## Application by The Drovers Solar Farm Limited for an Order Granting Development Consent for The Drovers Solar Farm

### The Examining Authority's (ExA) schedule of proposed changes to the applicant's draft Development Consent Order (dDCO) (Revision 04) [\[REP4-003\]](#)

Issued on: 29 September 2026

Inset A

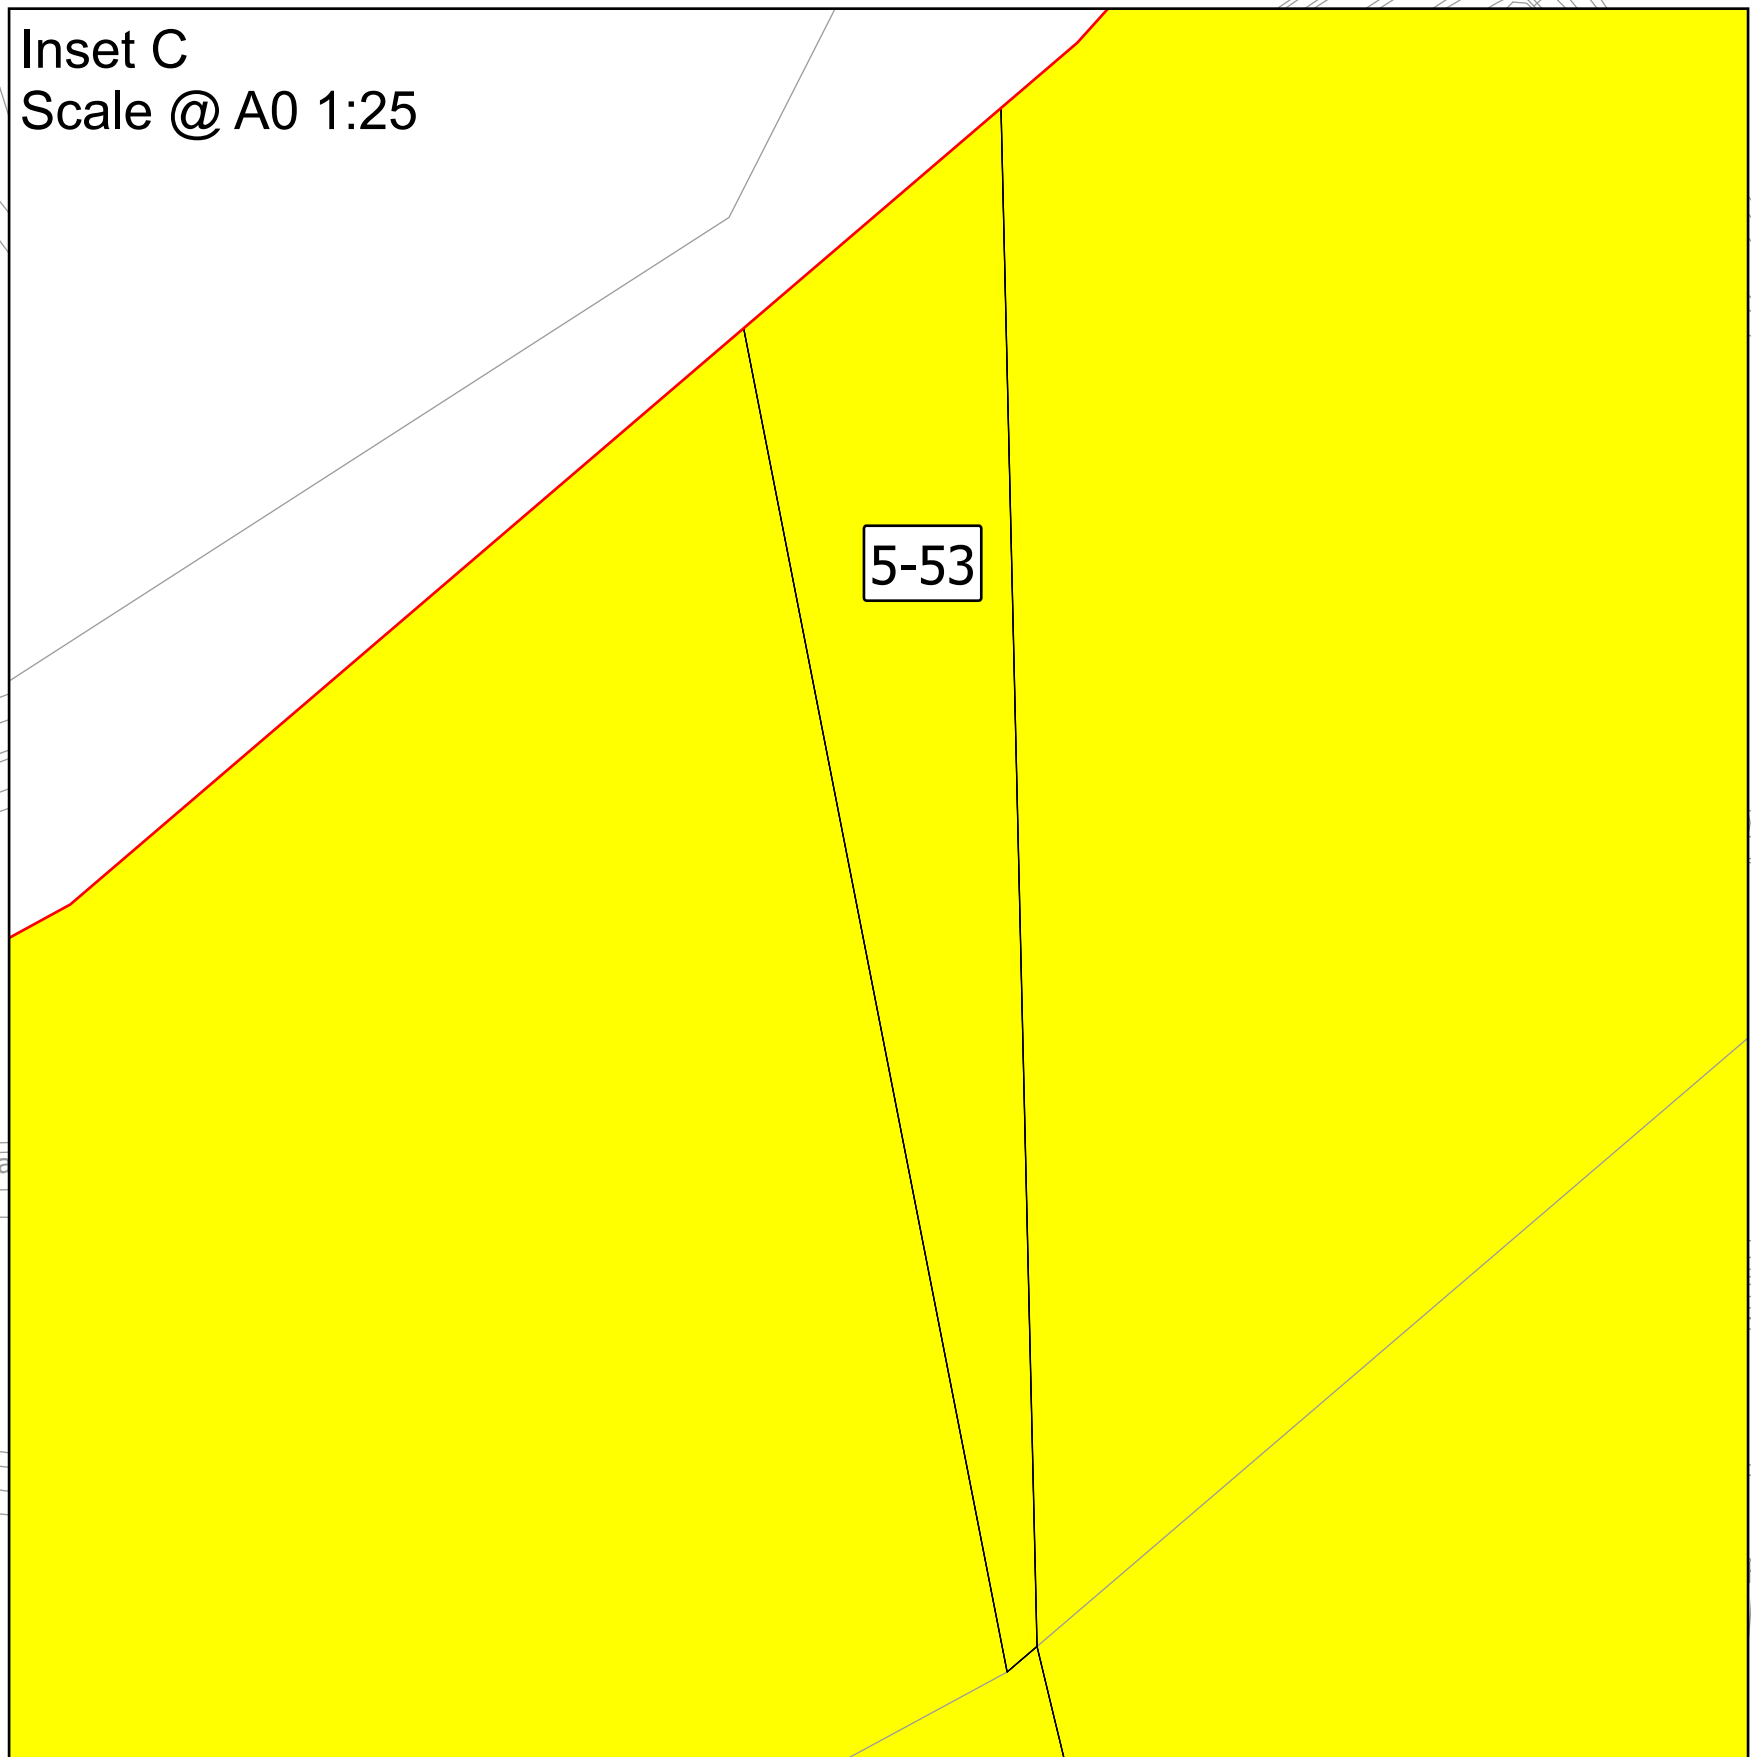
| Article/<br>Schedule                                                 | ExA's proposed changes<br>Deletions shown as strike through (for example)<br>Insertions shown in bold (for example)                                                                                                                                                                                                                                                                                                                                                                           | ExA's reasoning and comments                                                                                                                                                                             |
|----------------------------------------------------------------------|-----------------------------------------------------------------------------------------------------------------------------------------------------------------------------------------------------------------------------------------------------------------------------------------------------------------------------------------------------------------------------------------------------------------------------------------------------------------------------------------------|----------------------------------------------------------------------------------------------------------------------------------------------------------------------------------------------------------|
| Schedule 11                                                          | (1) Plot reference number shown on the Land Plan<br>1-08, 2-12, 2-33, 2-34, 2-35, 4-46, <del>5-47, 5-49,</del><br><del>5-50, 5-51, 5-53, 5-54, 5-55, 5-56</del>                                                                                                                                                                                                                                                                                                                               | In respect of each plot in the Book of Reference (5-47, 5-49, 5-50, 5-51, 5-53, 5-54, 5-55, 5-56) National Highways (NH) is identified as either a Category 1 person (as Owner/Occupier) or a Category 2 |

| Article/<br>Schedule                       | ExA's proposed changes<br>Deletions shown as strike through ( <del>for example</del> )<br>Insertions shown in bold ( <b>for example</b> ) | ExA's reasoning and comments                                                                                                                                                                                                                                                                                                                                                                                                                                                                                                                                                                                                                                                                                                                                                                                          |
|--------------------------------------------|-------------------------------------------------------------------------------------------------------------------------------------------|-----------------------------------------------------------------------------------------------------------------------------------------------------------------------------------------------------------------------------------------------------------------------------------------------------------------------------------------------------------------------------------------------------------------------------------------------------------------------------------------------------------------------------------------------------------------------------------------------------------------------------------------------------------------------------------------------------------------------------------------------------------------------------------------------------------------------|
|                                            |                                                                                                                                           | <p>person (holding rights granted by a Deed of Exchange dated 17 December 1984).</p> <p>The ExA is minded to agree with NH that the proposal to acquire temporary possession over NH's land does not accord with the Government guidance on the basis that it not necessary or proportionate for these powers to be included in the DCO when an alternative approach is available. The ExA agrees with NH that given the extent of the works proposed and given the availability of NH's normal process for enabling such works, there is no need for these works to be included in the DCO.</p> <p>Plots 5-47, 5-49, 5-50, 5-51, 5-53, 5-54, 5-55 and 5-56 should be removed from the Book of Reference, the Order Limits, and any other relevant application documents in which they are currently referred to.</p> |
